Environment, Climate Change & Water

RE: Exhibition submission for proposed Dargues Reef Gold Mine (MP10_0054)

ATTACHMENT 1 – Environmental Issues

Figure 4.26
 SIMULATED PIEZOMETRIC
 DRAWDOWN - END YEAR 5

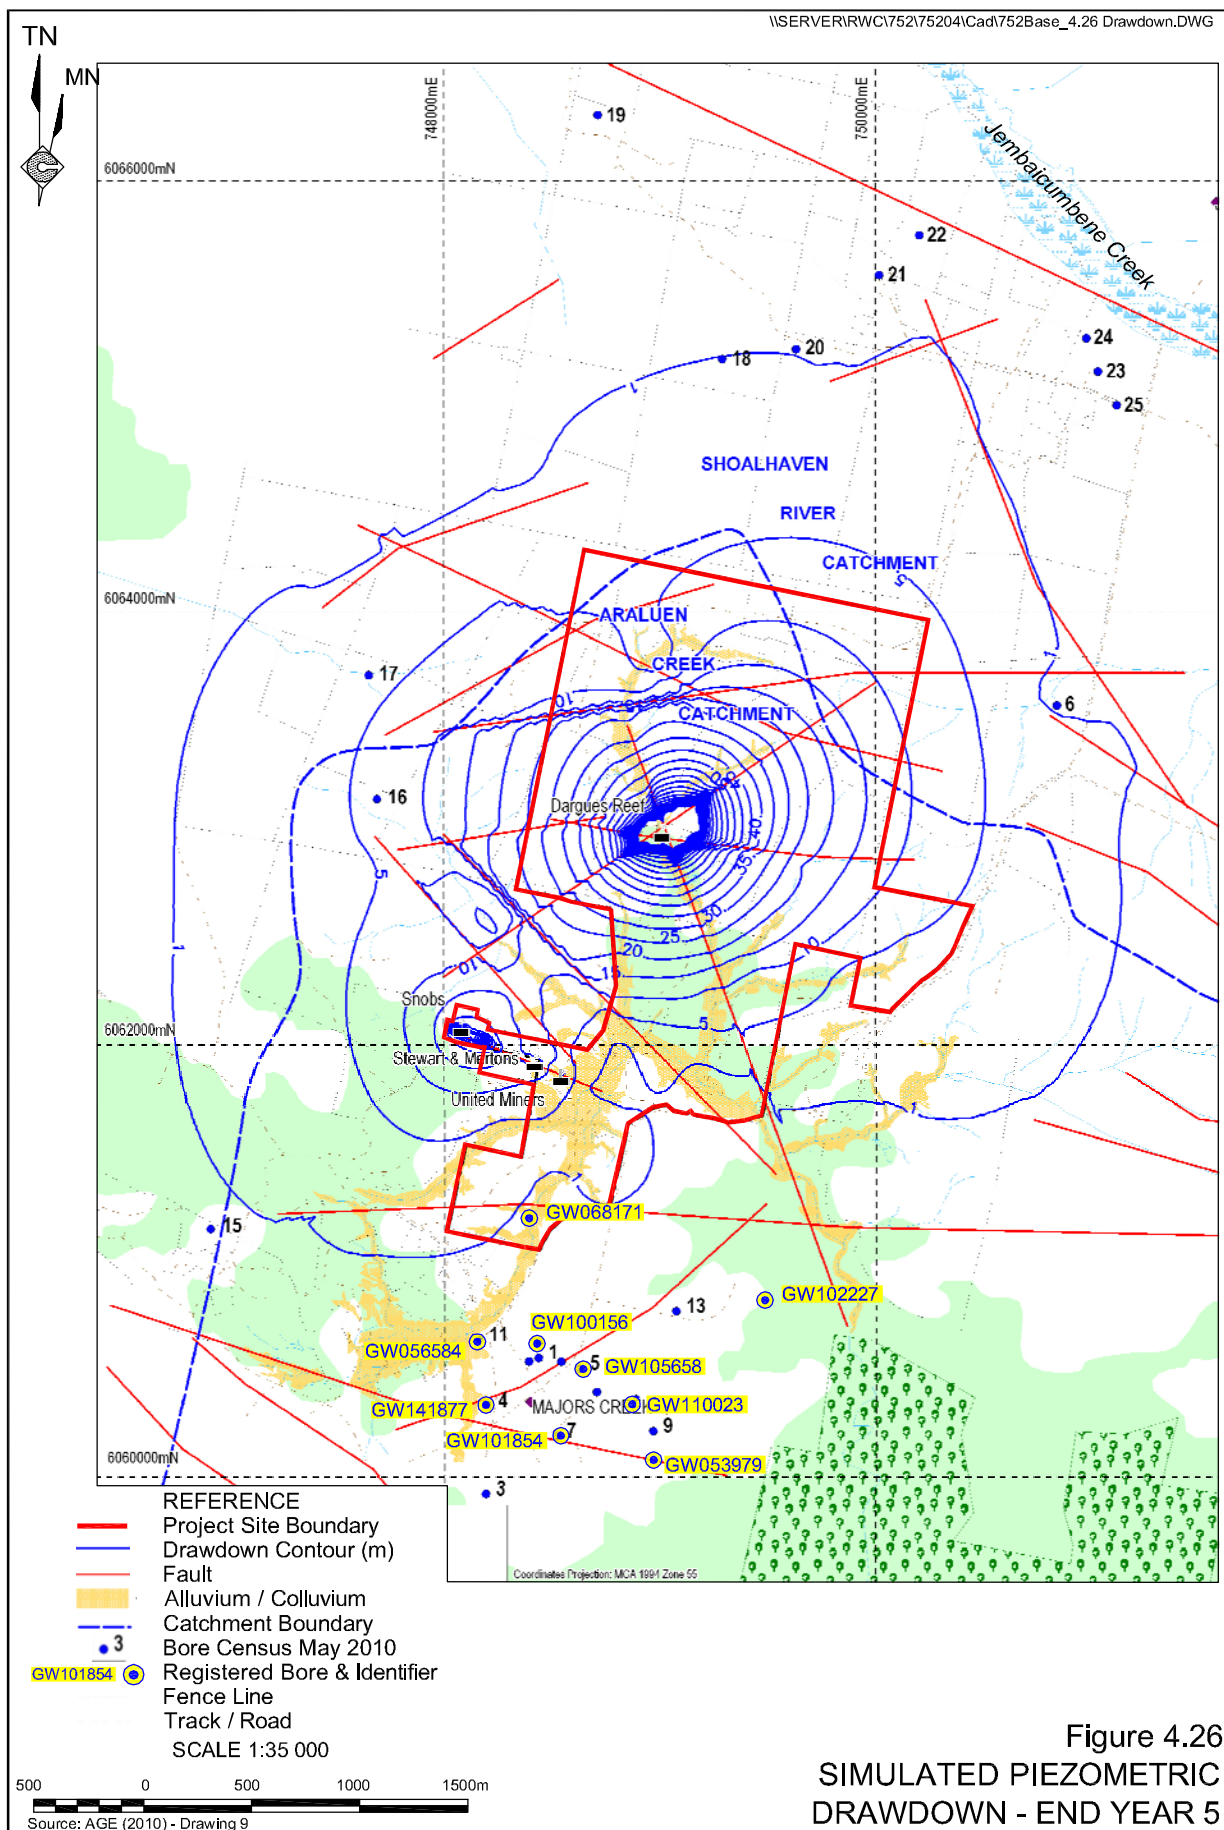
Environmental Assessment – Section No. 4: Assessment and Management of Key Environmental Issues. 4.4.5.6 Impact on groundwater dependent ecosystems pg 4-94 This section states that the project is “*not expected to result in adverse impacts to groundwater dependant ecosystems as none are likely to exist within the site*”. In 4.4.2.2 Regional Groundwater Setting pg 4-72 the proponent assumes the fractured rock (granodiorite) is “hydraulically tight” and not able to transmit groundwater flow. This statement is in direct contrast to that of the Specialist Consultative Studies - Part 3: Groundwater Assessment which on pg 3-25 9.3.1 Distribution and Yield states that paired monitoring bores indicate “the two [granodiorite and regolith] aquifers are in direct hydraulic connection”. Therefore any changes in the granodiorite will affect the groundwater level in the two other aquifers and surface water systems not supplemented with compensatory baseflows such as Majors Creek. This is evidenced in Appendix 6: Drawdown and recovery contours – Years 1-8.

PWG would like to make reference to the occurrence the Endangered Ecological Community *Araluen Scarp Grassy Forest in the South East Corner Bioregion* contained within and around the Majors Creek SCA. This community and the SCA occurs less than 1km from the modelled extent of the groundwater 1m drawdown contour. The final determination for this community expressly states that “*The community is susceptible to extreme dry spells*” and that “*Field sampling in 2003-04 identified extensive dieback of eucalypt crowns and understoreys attributed to recent extended drought, particularly on the spurs of the escarpment*” which testifies the importance of groundwater security for this community.

Additionally, a number of vegetated streams feeding Majors Creek outside of the proposed site still fall within the 1m drawdown contour, one at least falling within the 5m contour. It is likely that in times of drought, the vegetation contained within these stream corridors relies on groundwater for survival. Groundwater seepage would appear to be a key contributor in the replenishment of pools and freshes within the streambed and thus be utilised by a range of native fauna species during dry times. It is of our opinion that impacts from the changes to groundwater levels on the ecosystems of the Majors Creek SCA namely the *Araluen Scarp Grassy Forest in the South East Corner Bioregion* and impacts on the fauna and vegetation utilising streams adjacent the project site should have been considered in the EA.
